# CITY OF ALBUQUERQUE

RE: **SUMCO Parking Slab** - 9401 San Mateo NE  
Grading Plan for Paving Permit

File: **B17-D002**

Based upon the information provided in your submittal received 3/14/14, the subject Grading Plan cannot be approved for Paving Permit.

C101

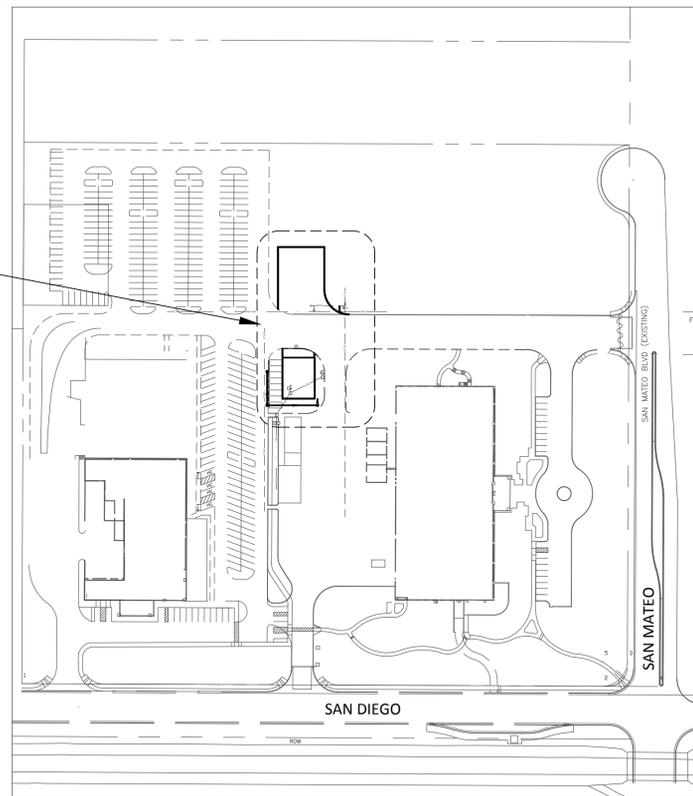
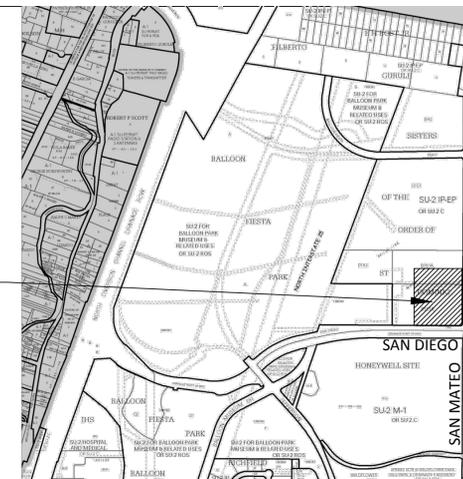
- PO Box 1293
- Albuquerque
- New Mexico 87103
- www.cabq.gov
1. This plan needs to site the Engineer and Seal date on the referenced, approved Grading and Drainage Plan. (Approved G&D prepared by Mike Emery, PE, Bohannon Huston Inc.: Sealed 10-31-1996 for affected portion of the site revisions.)

2. The Temporary Bench Mark provided on this plan needs to be tied to the City monument system, and NAVD88, or appropriate datum datum.
  3. The latest approved plan in our files is a Grading Certification for a building addition, with a PE seal of 11/19/1997. That plan shows a private storm drain system with a manhole and intersecting drain lines crossing under the landscaped area at the proposed slab. Verify that there are no conflicts.

4. The 11/19/97 plan also states that a proposed 24" drain and Double D inlet must be constructed in the area north of the NW parking lot, after the outfall line is completed on the site to the north. That outfall was completed in 1996. Our records show no confirmation that the onsite work was done. Provide documentation of the existing conditions being in compliance with the approved plan. If these facilities have not been constructed, we will require them to be constructed at this time.

5. The 11/19/97 plan also shows a swale (Section B-B) along the east side of the NW parking lot, which will divert sediment around the pavement to the NW pond. The grades on this plan do not reflect existence of the swale. Provide grading to prevent storm runoff from washing sediment into the drainage system.
